Charlotte Department of Transportation

Memorandum

Subject: Rezoning Petition 2011-039: Located on the southeast corner of Providence Road and Alexander Road

**RZ1.0**

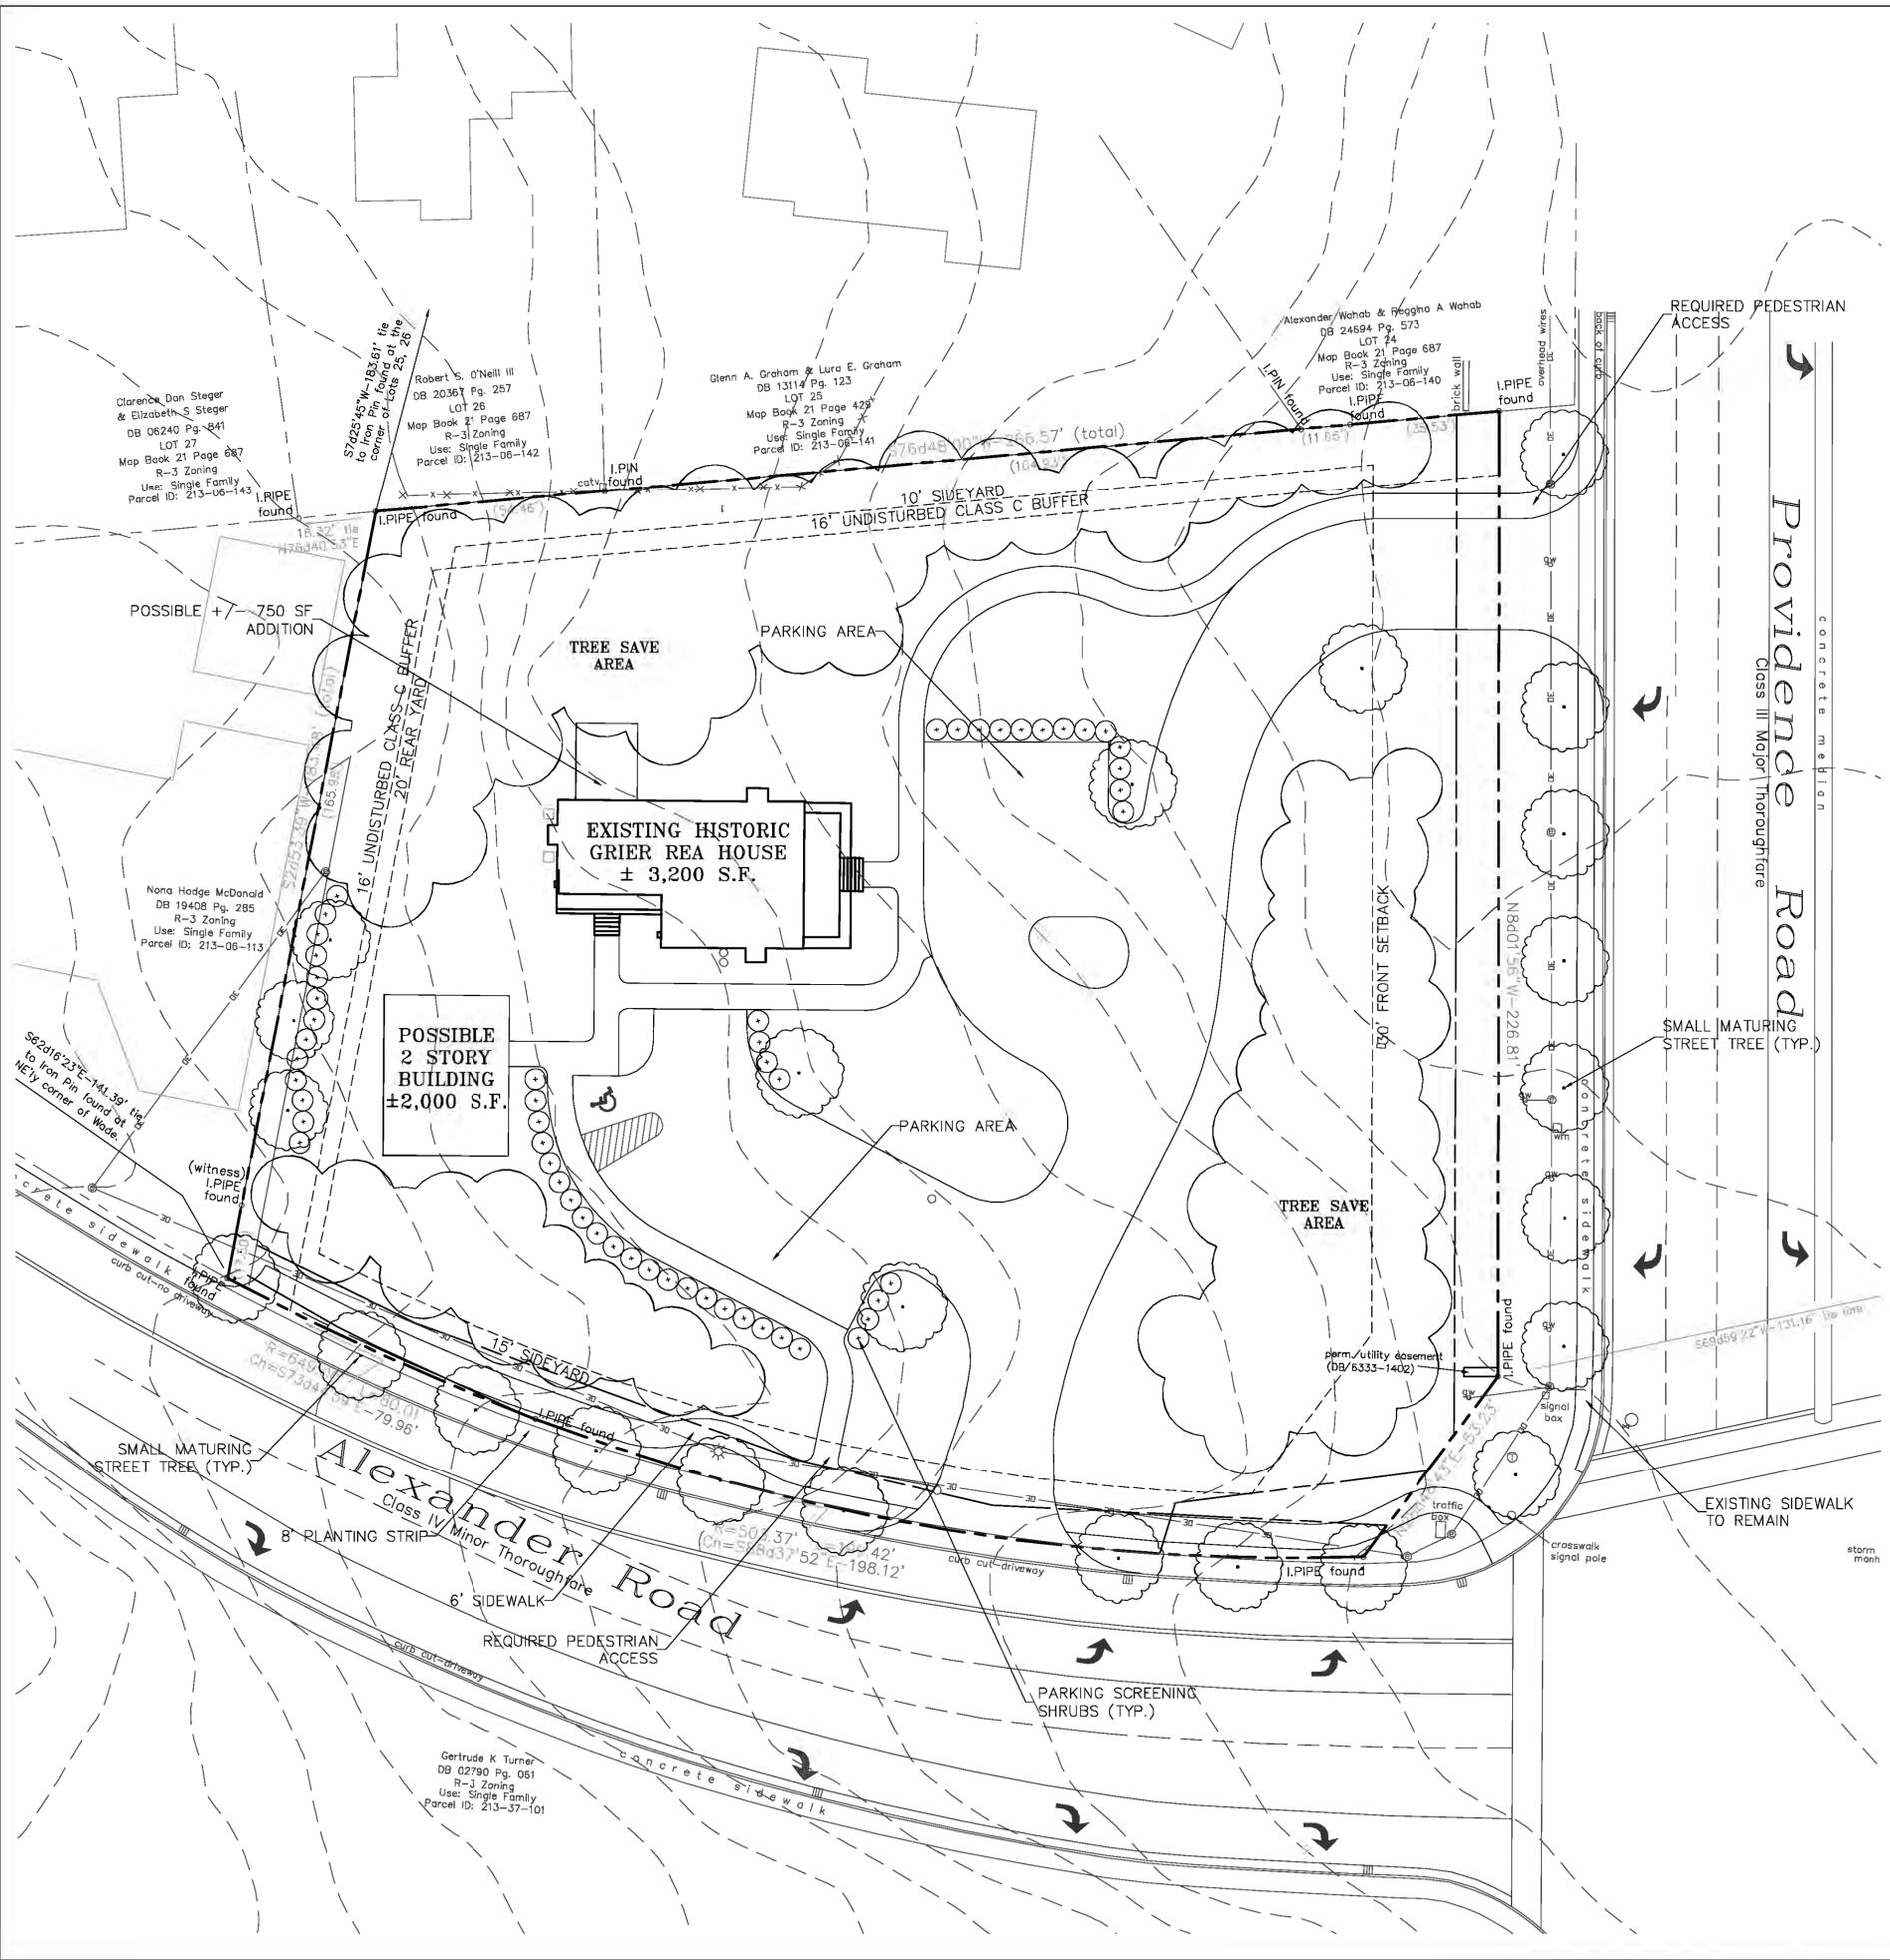
1. Per the subdivision ordinance, the minimum streetscape requirement is an 8' planting strip and 6' sidewalk across all street frontages.

1. Alexander Road is a minor thoroughfare requiring more than the minimum 70 feet of right of way in order to include the entire planting strip within the right-of-way. The developer/petitioner should convey right-of-way in fee simple title to meet this requirement.

1. Adequate sight triangles must be reserved at the existing/proposed street entrance(s). Two 35' x 35' and two 10' x 70' sight triangles are required for the entrance(s) to meet requirements. All proposed trees, berms, walls, fences, and/or identification signs must not interfere with sight distance at the entrance(s). Such items should be identified on the site plan.
